Abercrombie Precinct Development

**MP 07_0158 - Abercrombie Street Precinct, Syd Uni
University of Sydney Abercrombie Street Business School**

RE: Sydney University Abercrombie Precinct Redevelopment – Project Application (MP07_0158)

The City provides its comments in relation to the proposed University of Sydney to create a new Business School facility to support the Faculty of Economics and Business on the Abercrombie Precinct at the southern end of the Darlington Campus.

SITE PLAN

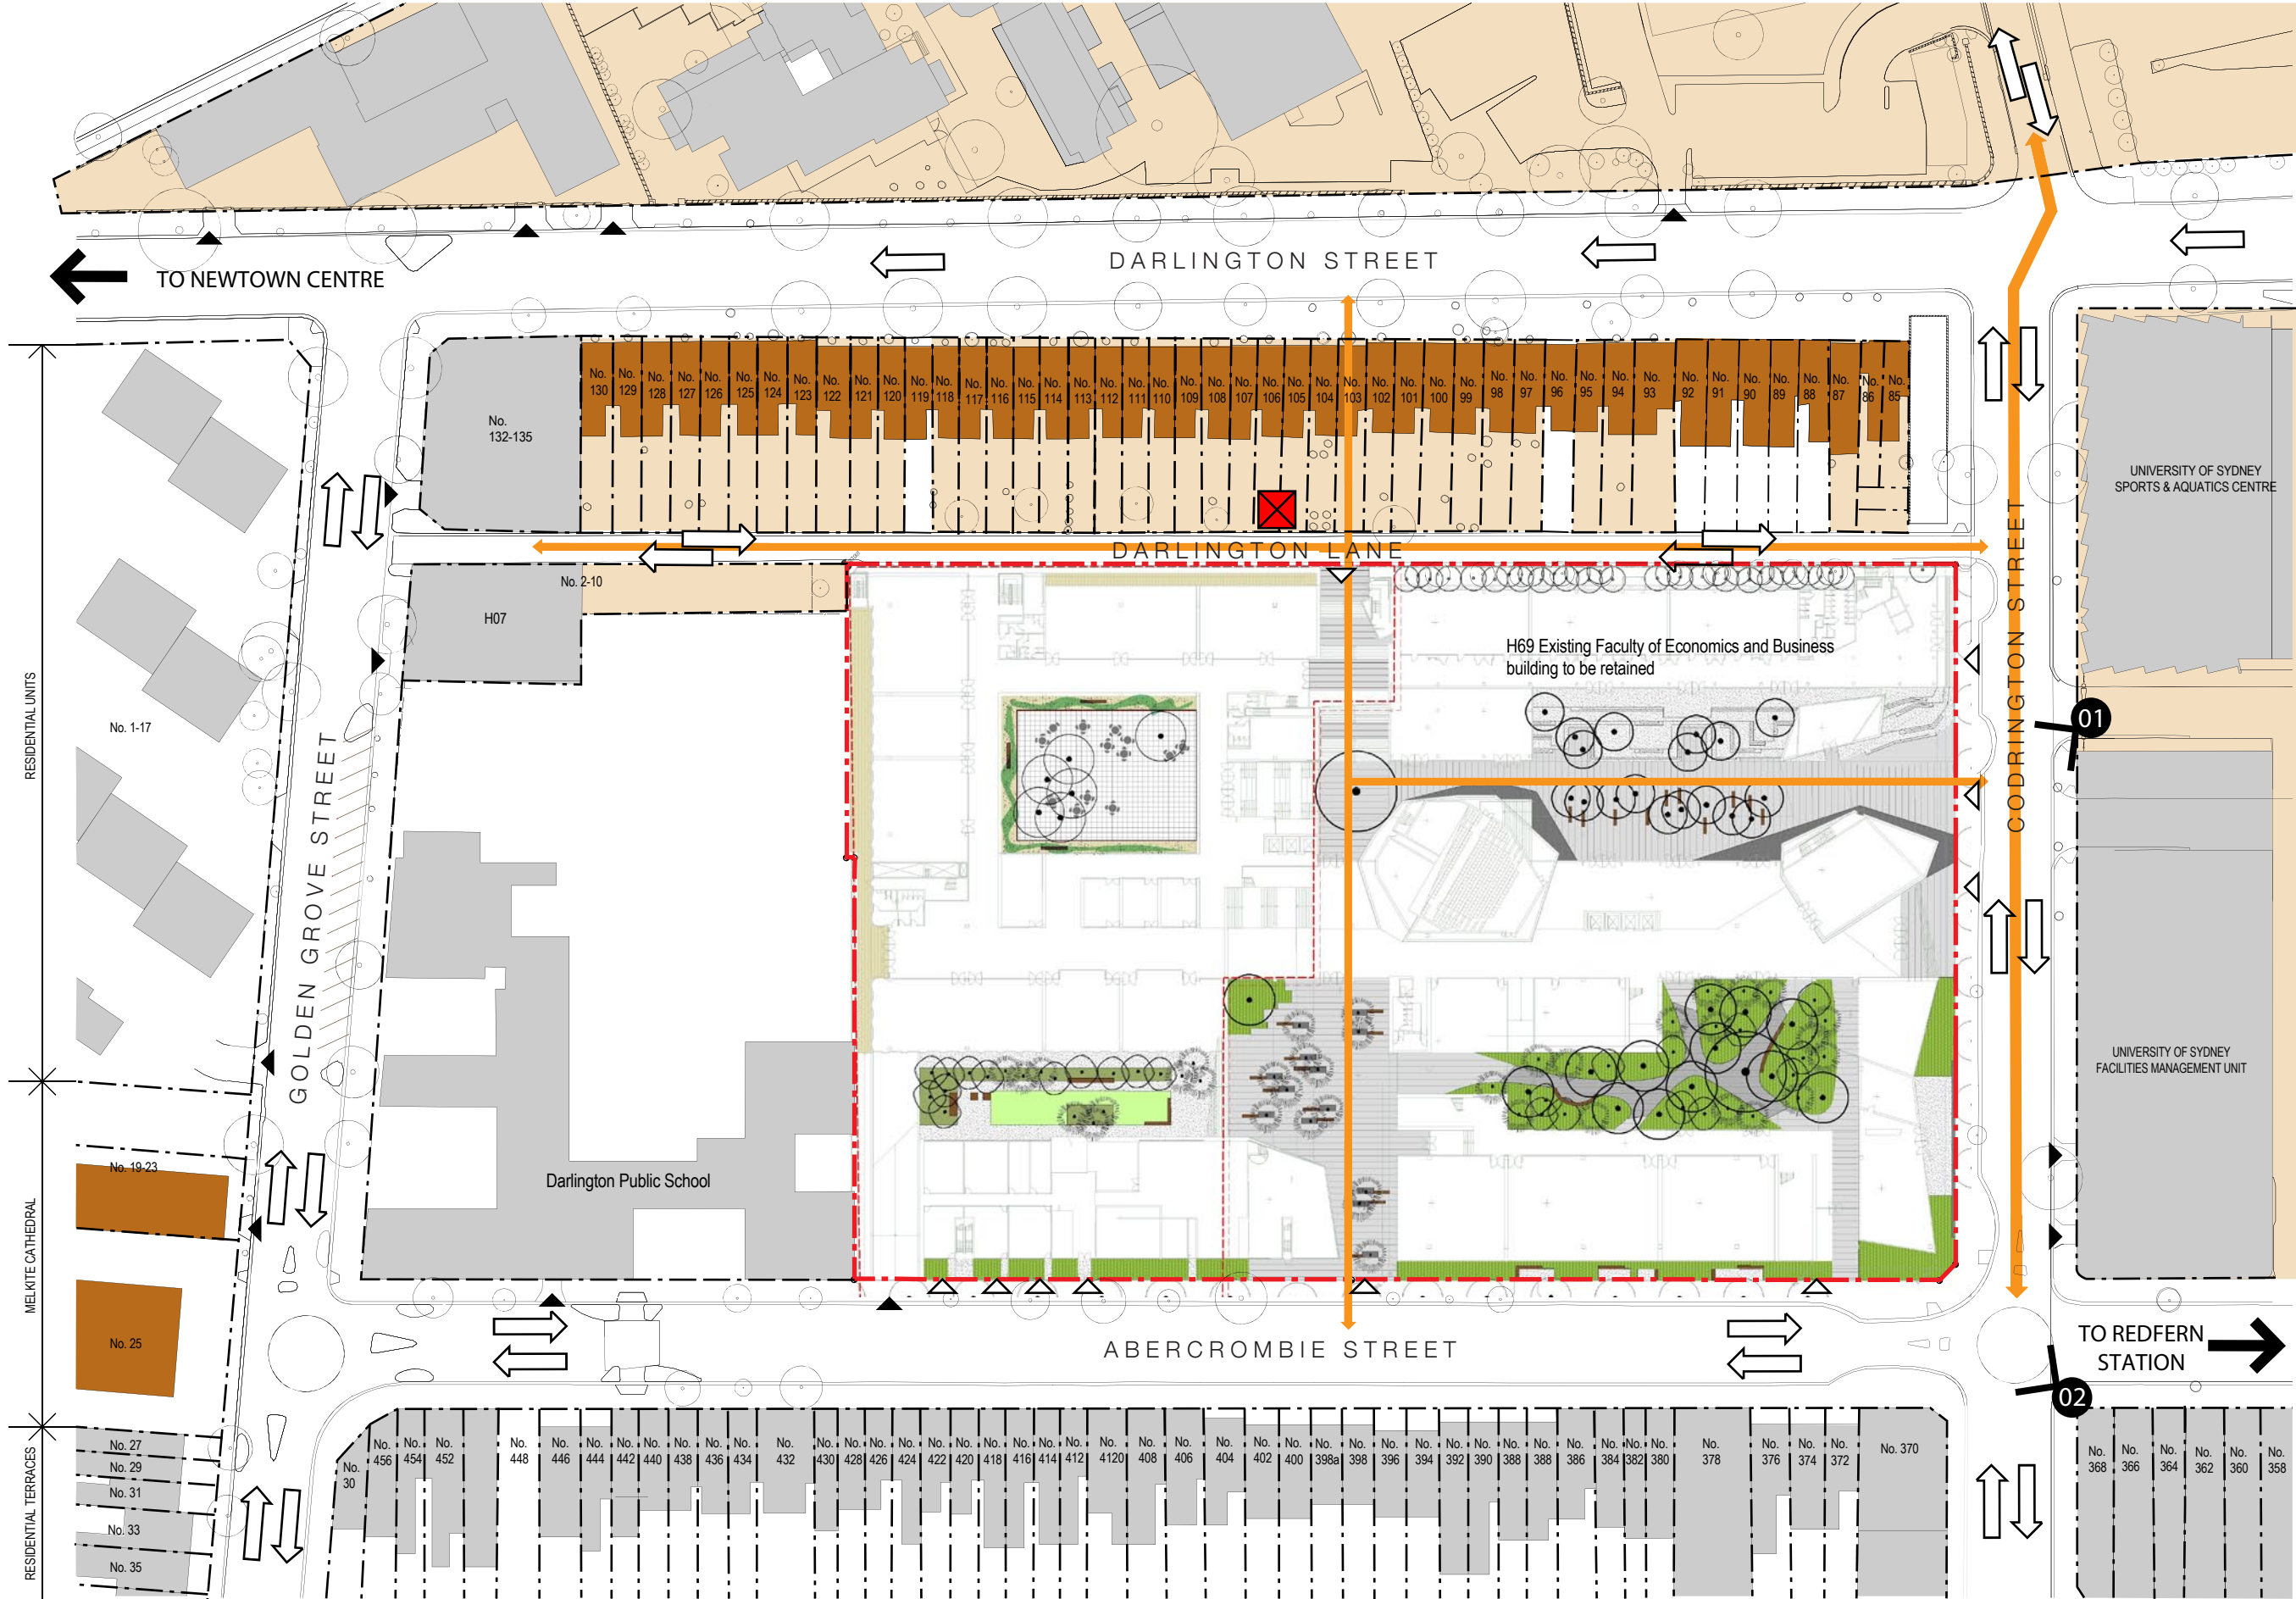
According to the Site Plan (A1002/3) prepared by Woods Bagot architects dated 9 March 2010, a new chamber substation is proposed in the rear of 105 & 106 Darlington Road. The Arborist Assessment states that within the rear yard of this property is a group of Lilly Pillies. The report states this group of trees has a high retention value.

The location of this new substation has not considered the likely impacts on existing vegetation. It is considered that several other locations could have been selected for this substation that would not require tree removal or impact on trees with high retention values

Abercrombie Street (South) Elevation

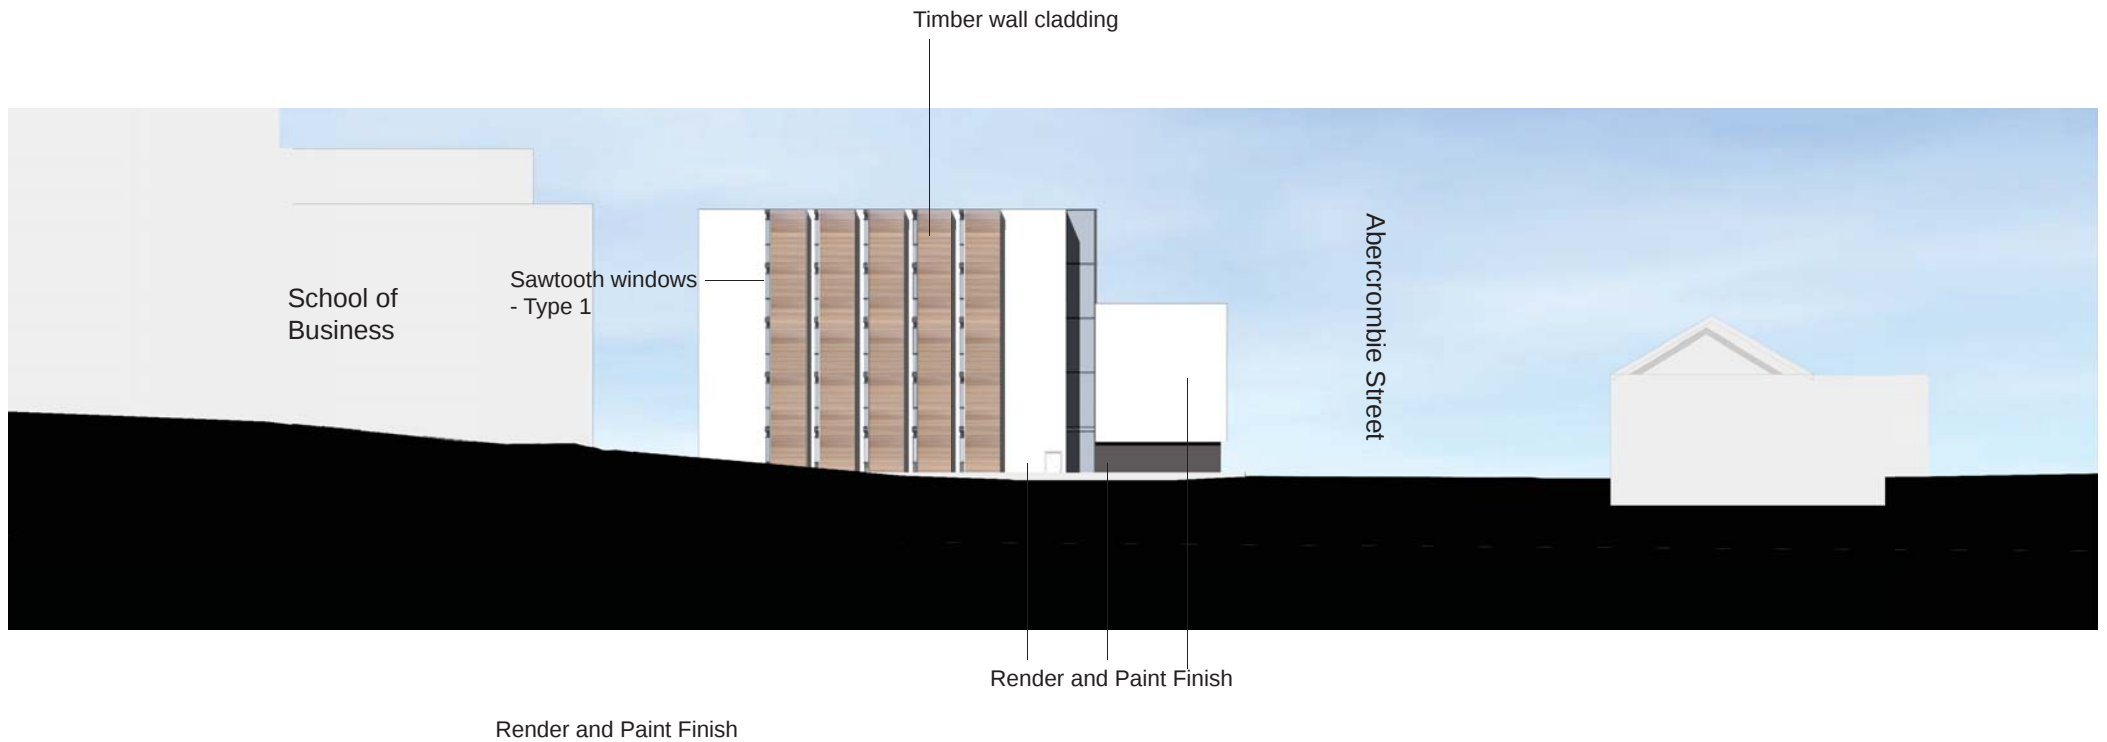
architecturally is contemporary in terms of massing, the strong horizontal lines of the exposed slabs that have been expressed on the street elevations fail to adequately respond to the fine-grain vertical character of the surrounding streets, and particularly along Abercrombie Street. The architectural character of the perimeter of the building needs to be amended by incorporating strong vertical articulation to ensure the buildings along Abercrombie Street harmonize with the character of the Victorian terraces.

The proposal has the potential to integrate well with the neighbourhood in that it has adopted a scale along the perimeter of the site which is not incompatible with its context. However in order to respect and respond appropriately to its context, further vertical emphasis in the facades is considered necessary.
